August 16, 2021

**RE: Letter of Intent
Mikey's Total Car Care
Lot 3, Lakeshore Industrial Park Special Use and Site Development
Plan**

**PRELIMINARY
SITE PLAN**

**PRELIMINARY
SITE PLAN**

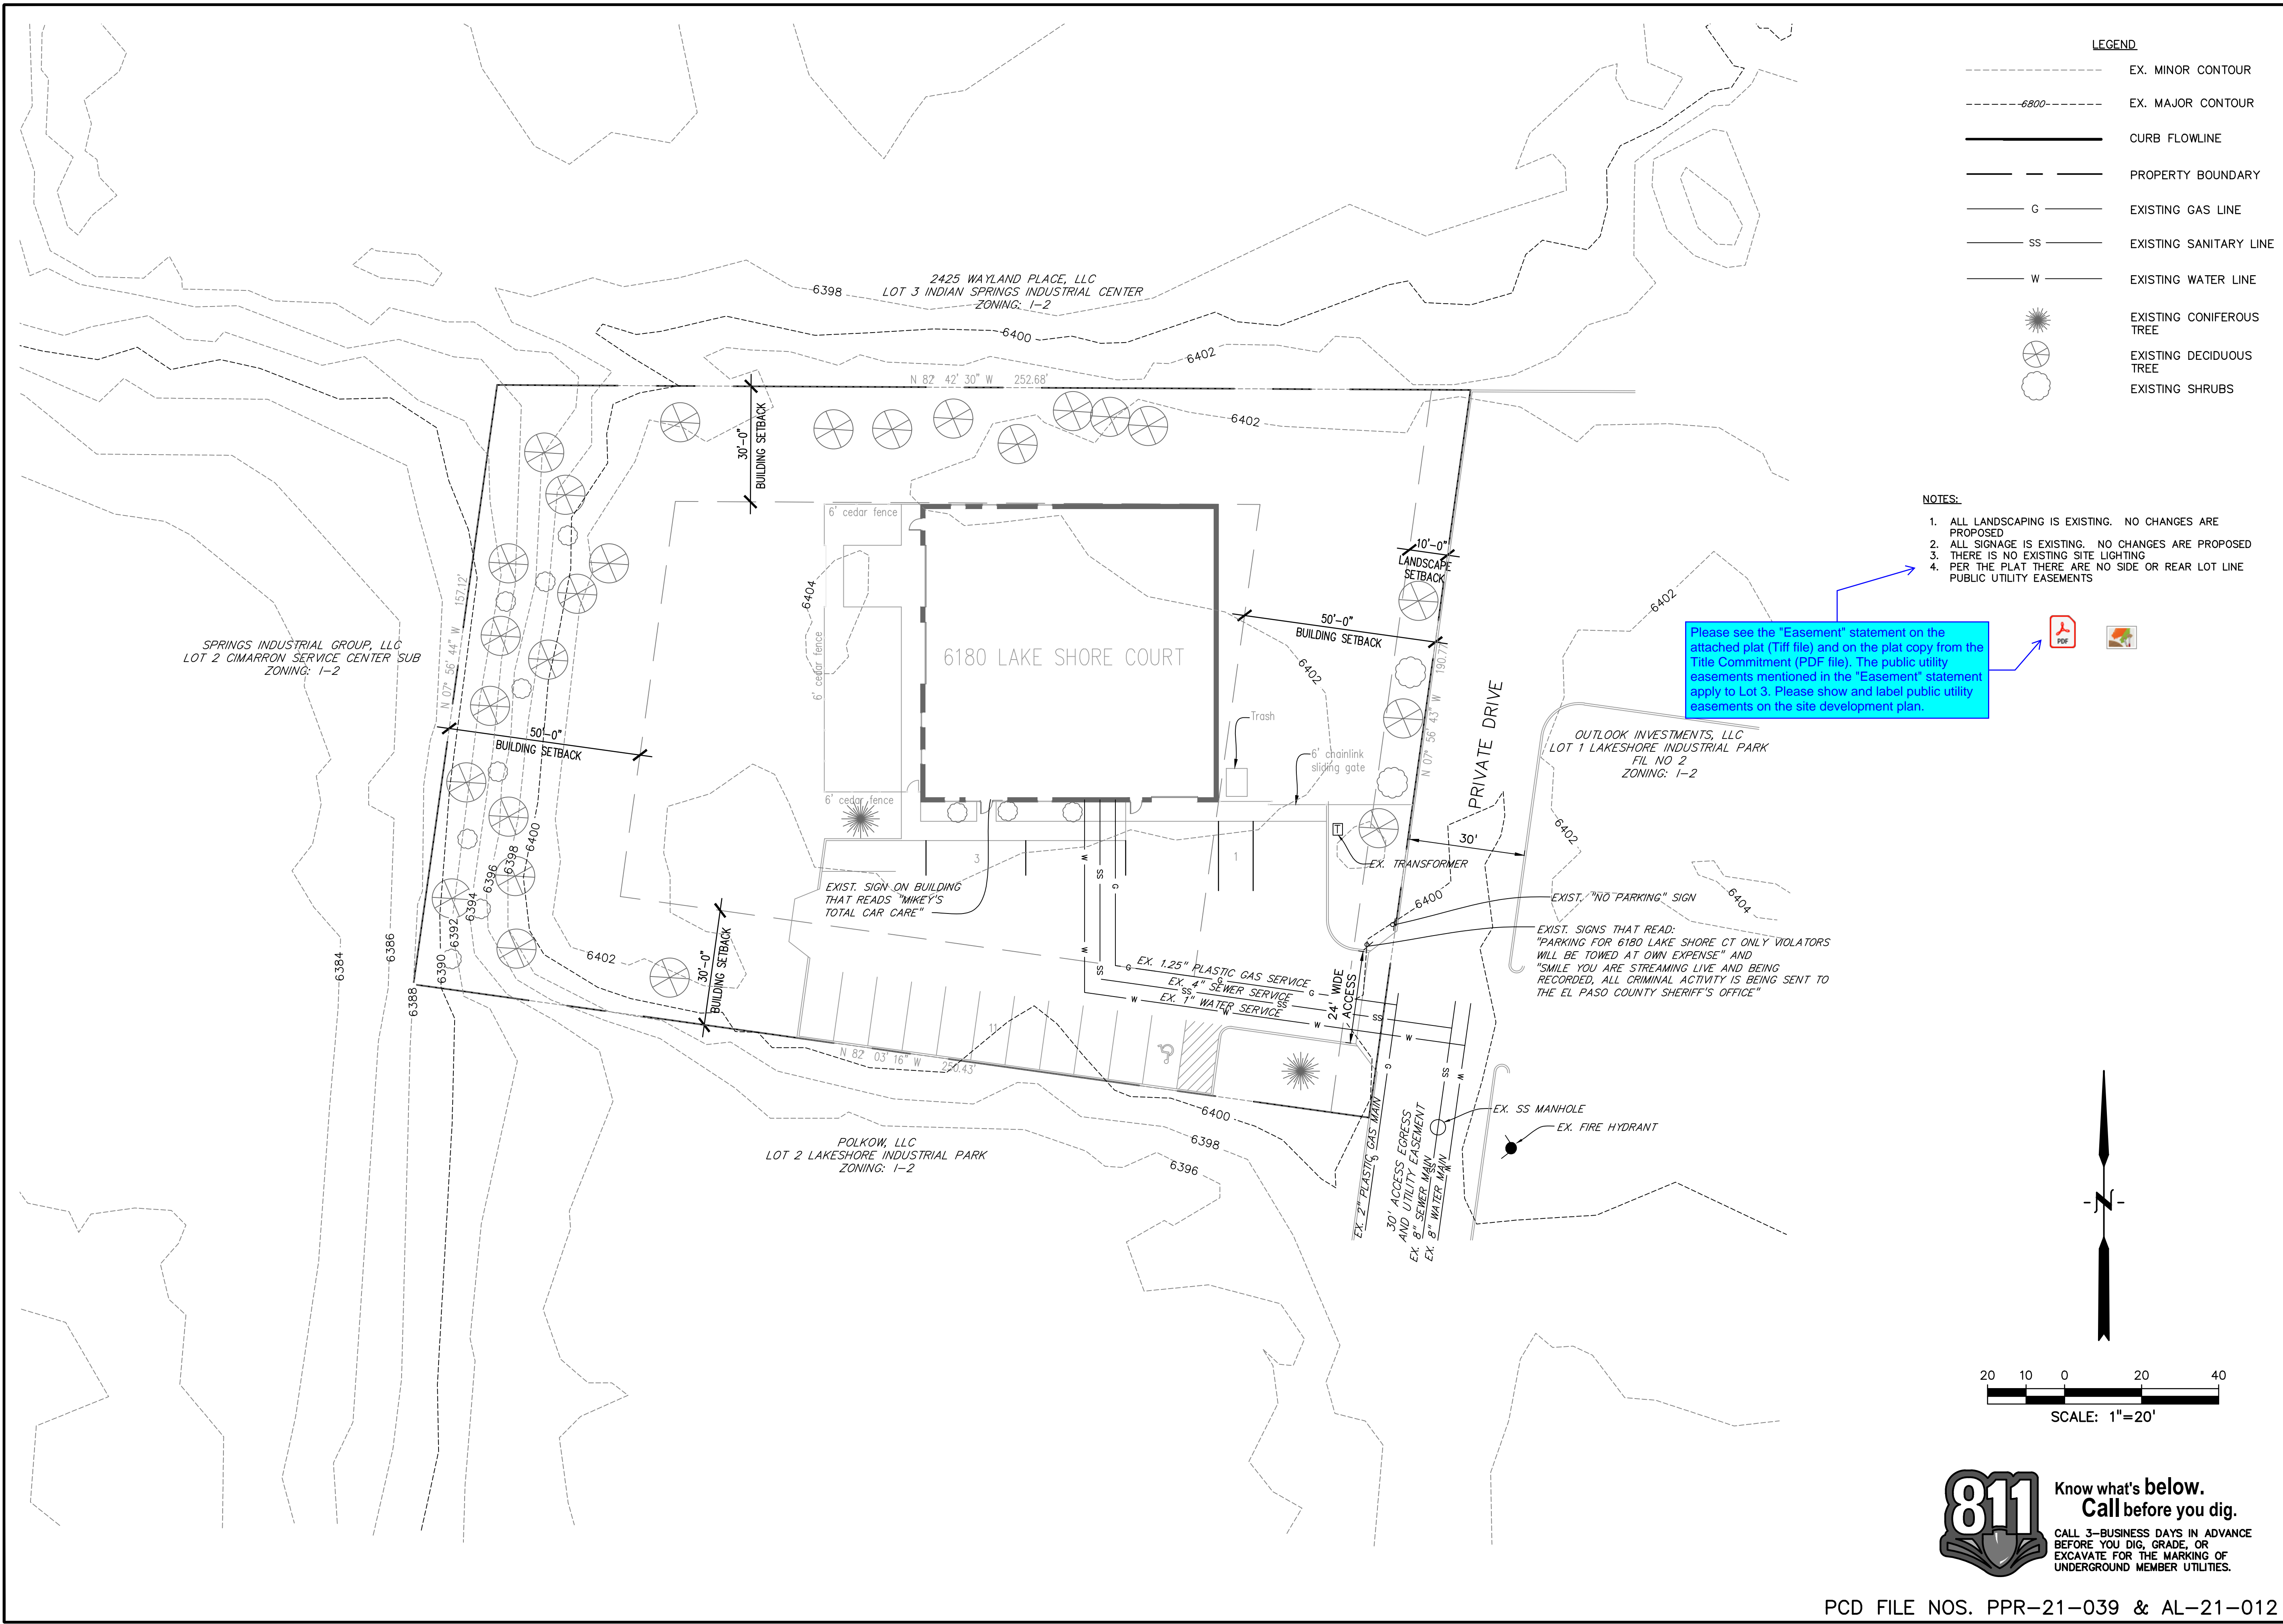
Please confirm the proposed use will not adversely impact adjacent properties or existing drainage patterns.

Please note applicant will be required to apply for a Driveway Access Waiver.
